Planning Inspectorate

Peartree Hill Solar Farm – EN010157

Section 51 advice regarding draft application documents

Issued on 26 November 2024

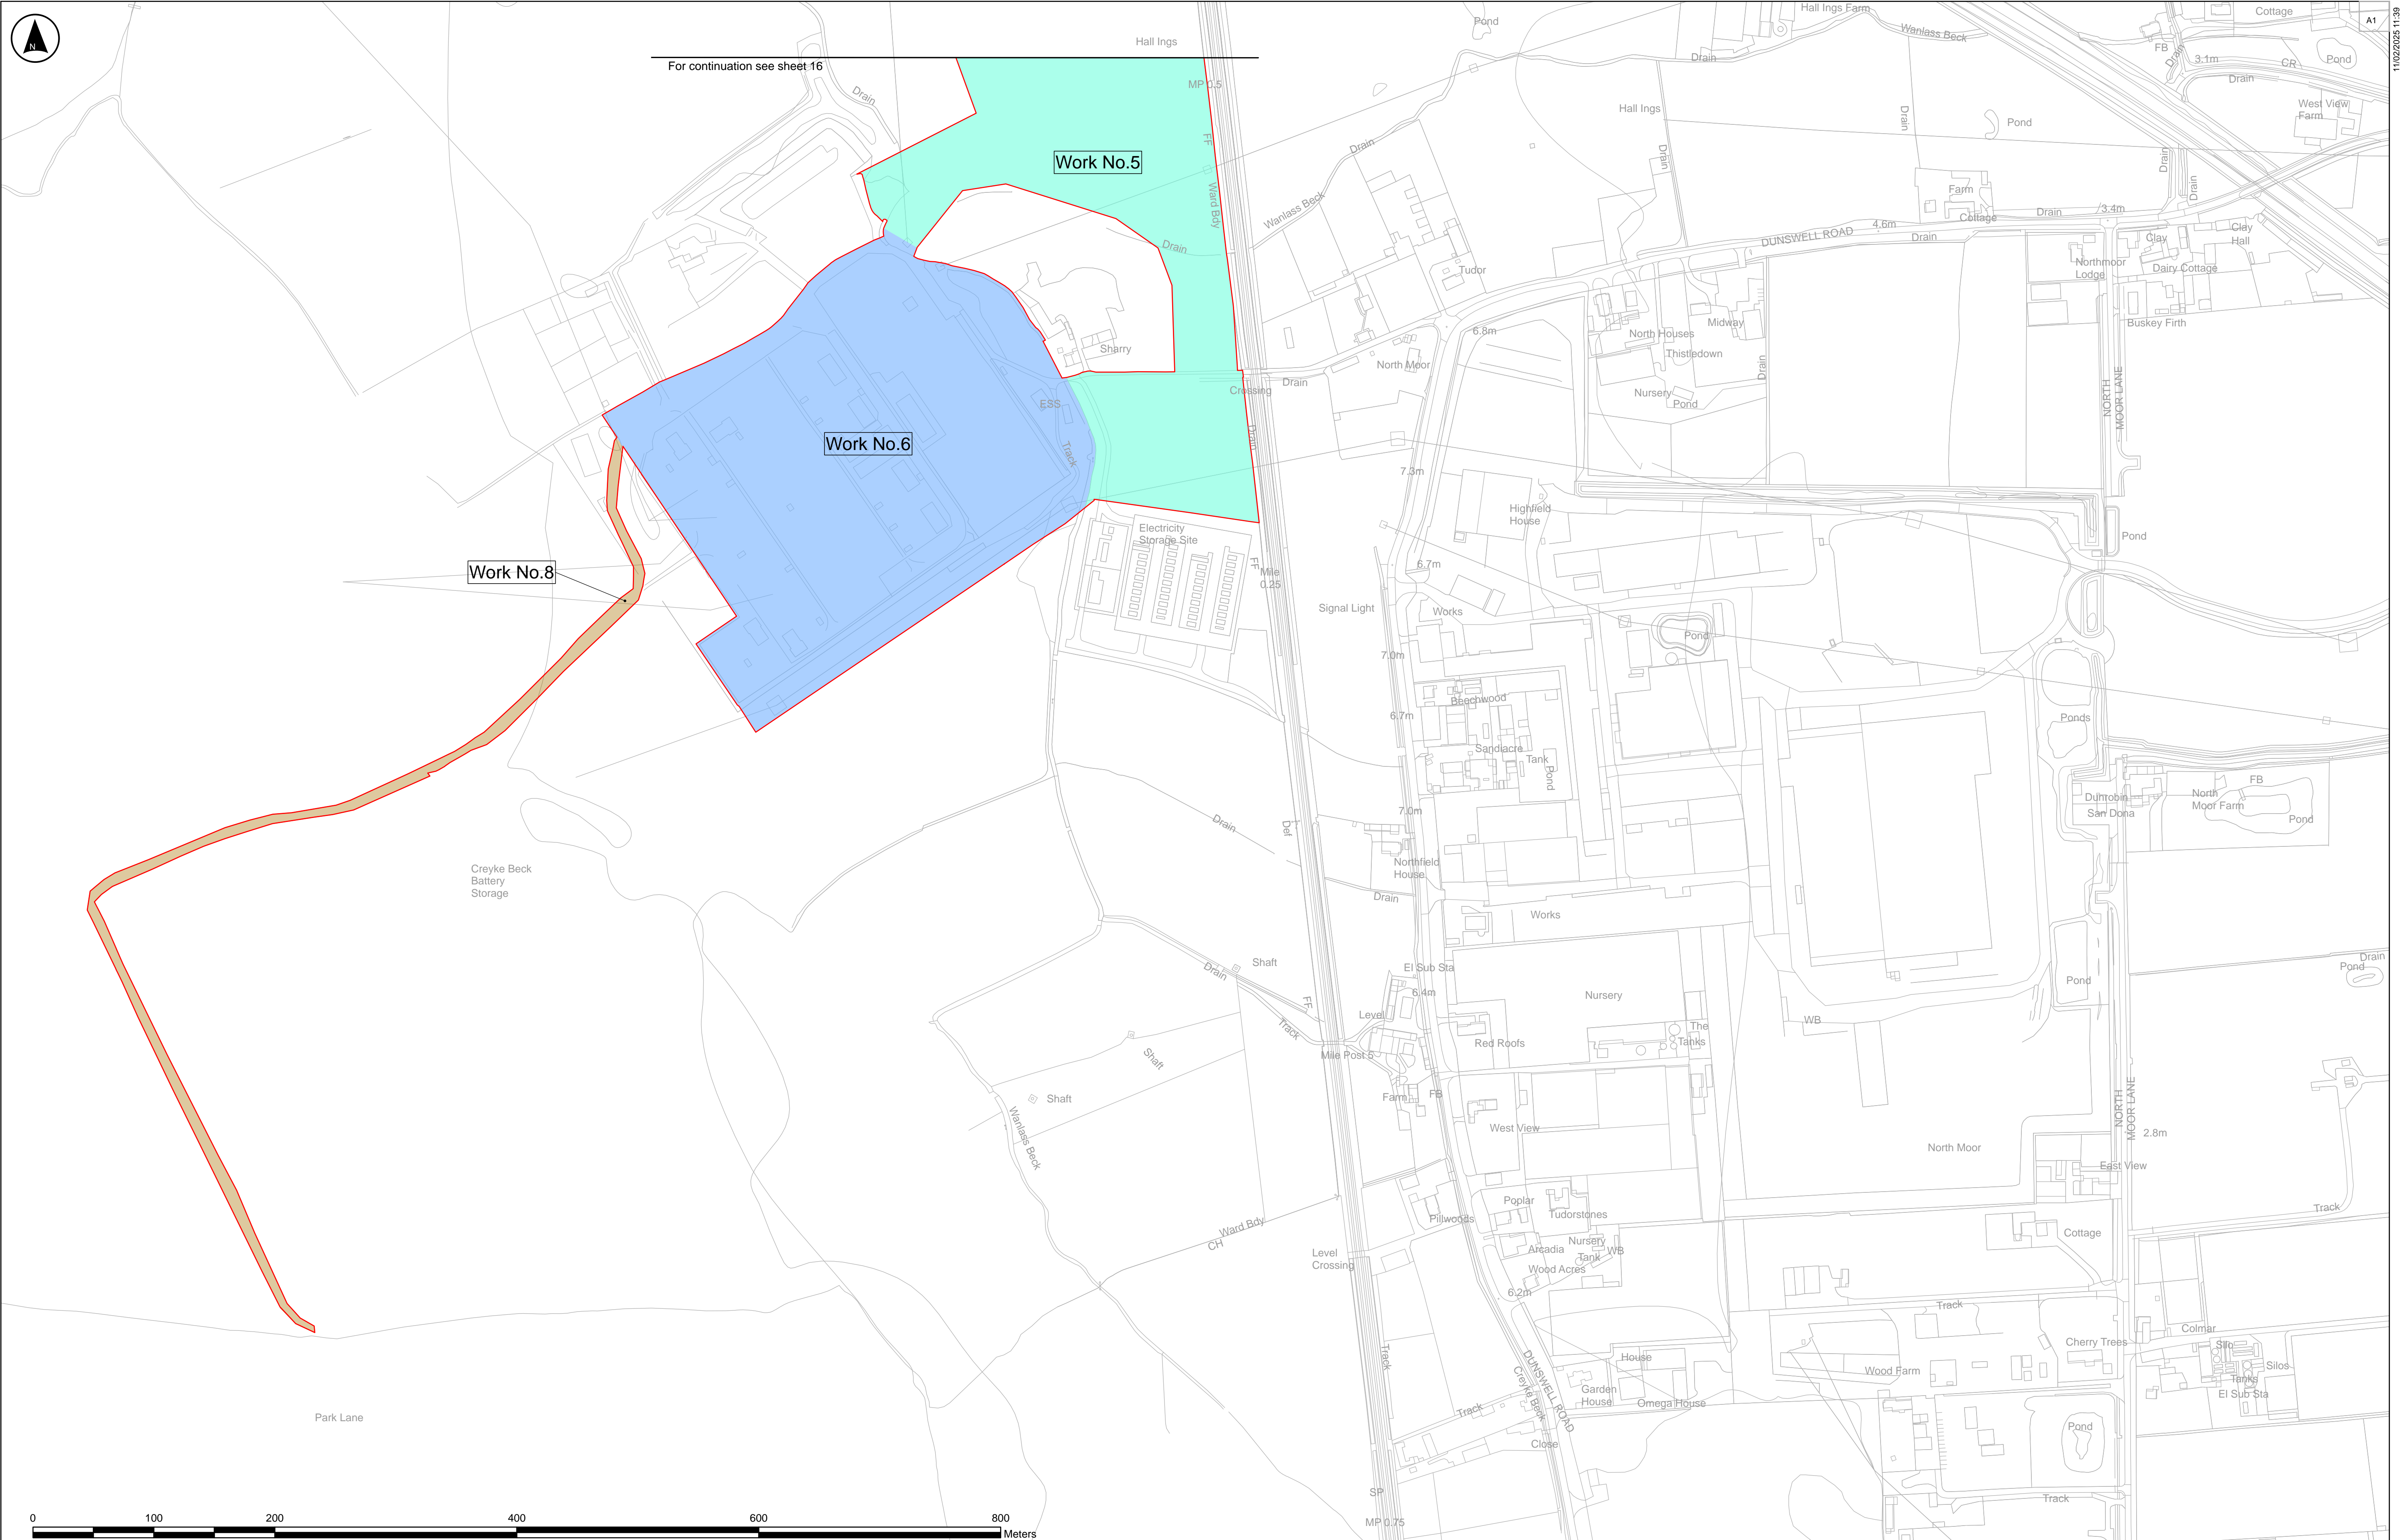
5.	Works Plans	The applicant should review the Works Plans to ensure that all works are labelled. For example, it is noted that at sheet 16, Work No.3 has not been labelled.
